Subject: FW: Consultation on planning application 3/2012/0269 land adj Myerscough Road, Mellor Brook
Graeme

I have now received a revised plan from the applicant's agent detailing the access arrangements for the development site, which now incorporates the 'ghost island' layout I requested. I therefore have no objection to this proposal, subject to the following conditions:

campbell driverpartners
 architects designers surv
 client: leehand properties ltd
 project: office development
 A59 Mellor Brook
 sheet: site plan

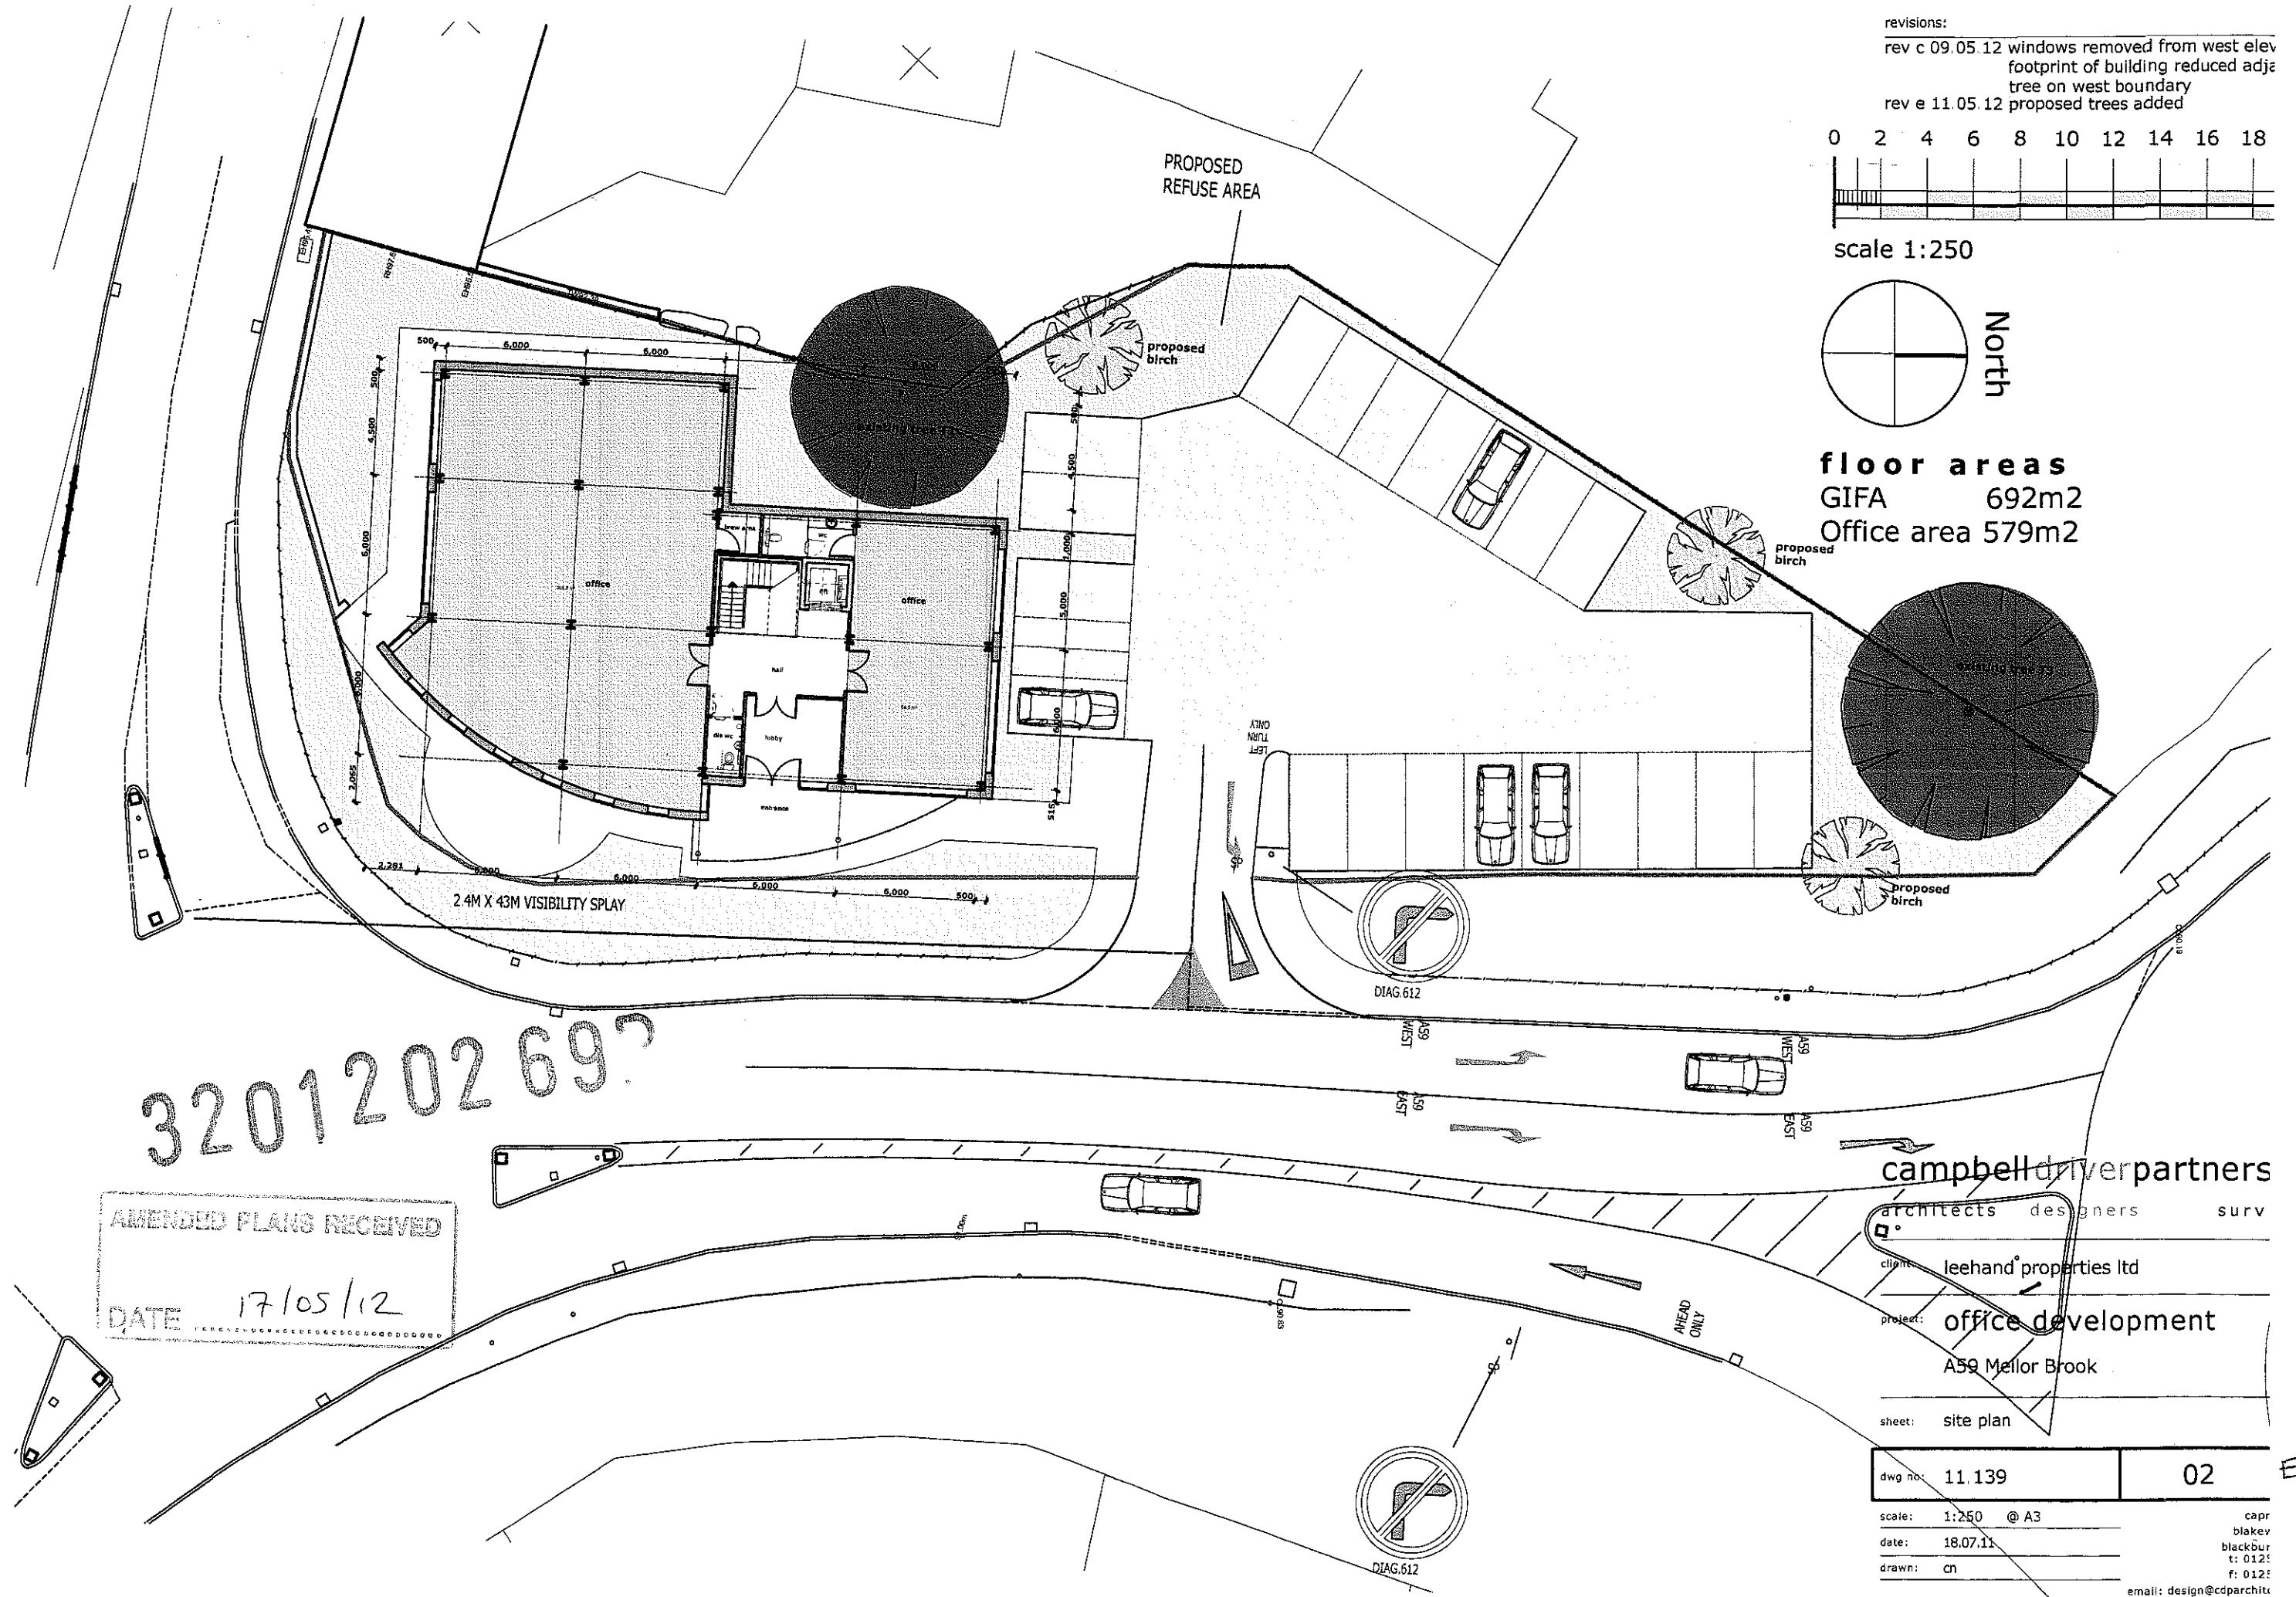
1. Any gateposts or barriers erected at the access shall be positioned 5m behind the nearside edge of the carriageway. Any gates shall open away from the highway. Reason: To permit vehicles to pull clear of the carriageway when entering the site.

4. The proposed access to the site shall be constructed to a minimum width of 5.5m between the car parking area and the nearside edge of the carriageway. Reason: To enable vehicles to enter and leave the premises in a safe manner without causing a hazard to other road users.
